Contact Janne Grose
Phone 4729 8262
Email Janne.Grose@dpi.nsw.gov.au
Our ref ER23041

**Environmental Impact Statement for Site 68 Bennelong Parkway, Sydney Olympic Park
(SSD 6603) [Our Ref: ER23041]**

The NSW Office of Water (Office of Water) has reviewed the Environmental Impact Statement and provides comments at **Attachment A**.

DA02.B1[07]

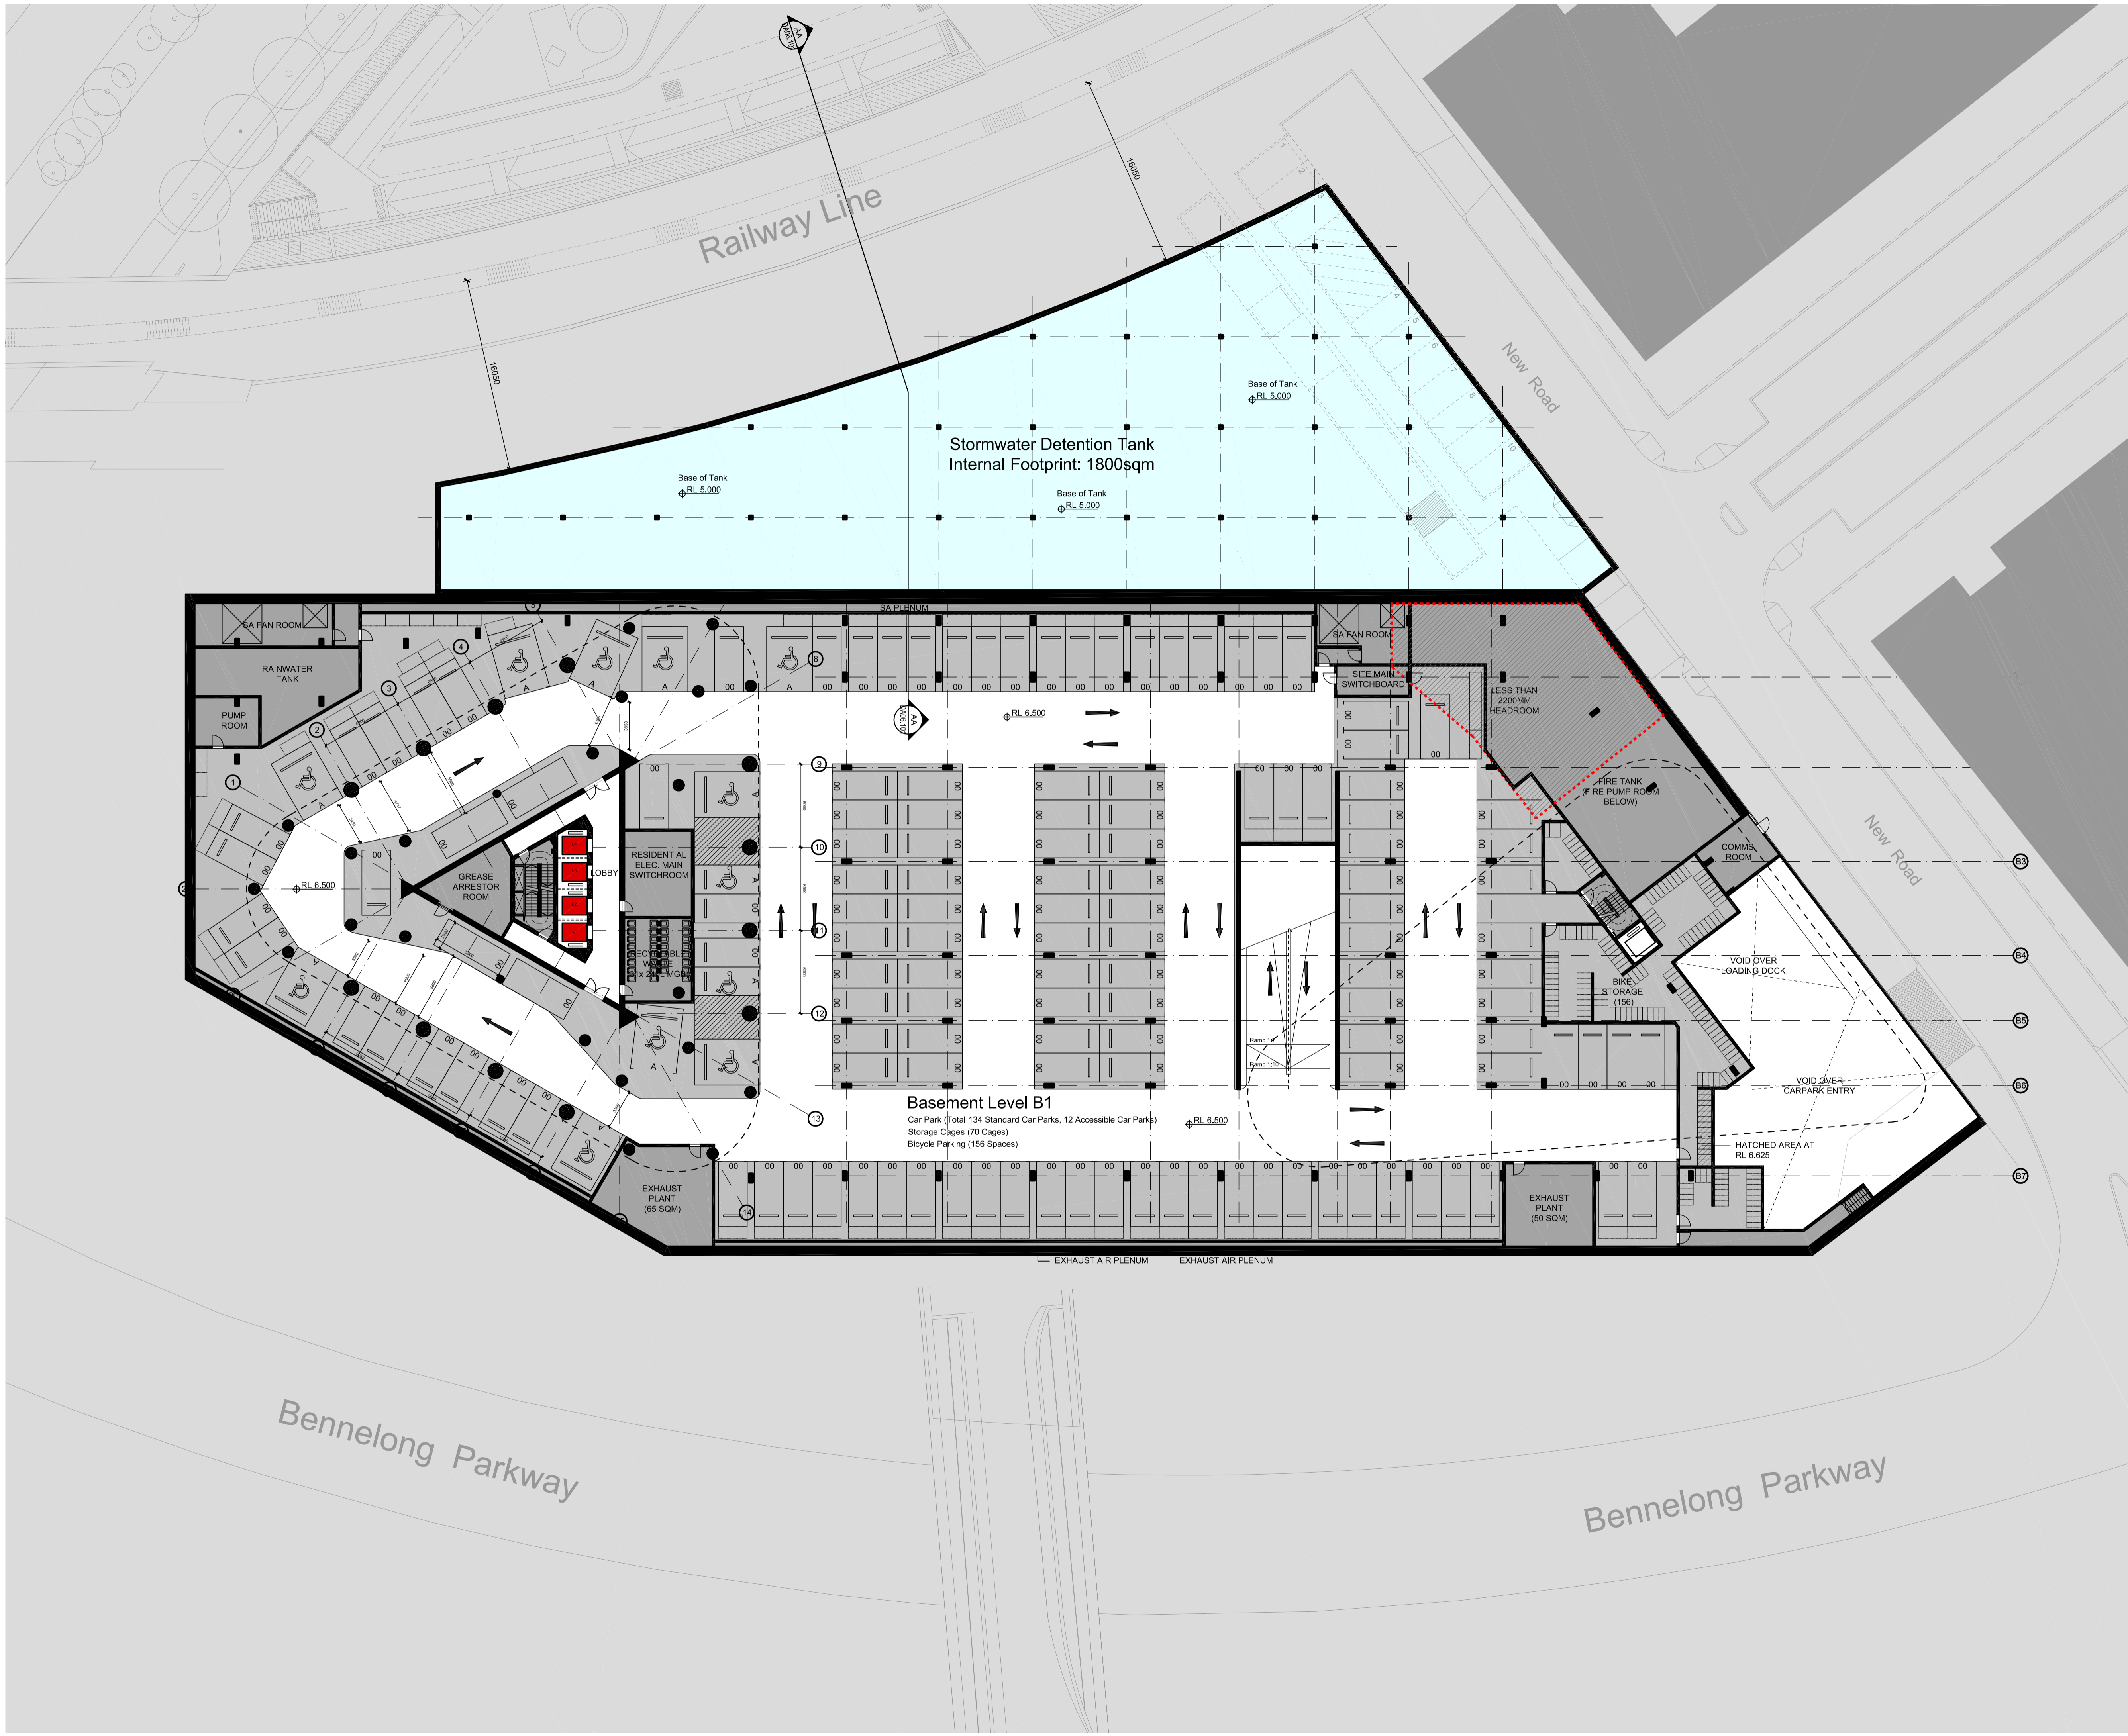
Section 8.4 of Appendix U indicates that only minor seepage will occur into the basement and a drained basement should be suitable. It indicates that if excessive flow rates or contaminated groundwater are issues then tanking or water licensing may be required (page 11). As advised in the Office of Water's SEARs submission for the project:

Section 8.13 of the EIS indicates that it is possible that groundwater may be contaminated and an assessment of the groundwater is currently being undertaken (page 65). It also includes a mitigation measure to assess groundwater quality to determine appropriate control and disposal options (Table 8, page 69). To assist the Office of Water in its assessment as to whether the basements need to be tanked, it is requested:

- a copy of the assessment report is provided to the Office of Water once it is finalised.
- suitably detailed and justified estimates are provided of the total volumes of groundwater likely to be dewatered

Section 8.4 of Appendix U notes pumps will probably be required to remove seepage from the basement and for pile excavations during construction (page 11). Details are required on the likely volumes to be pumped and where this water is proposed to be discharged. It is important the nearby Bennelong Pond is not impacted by any discharge of construction dewatering.
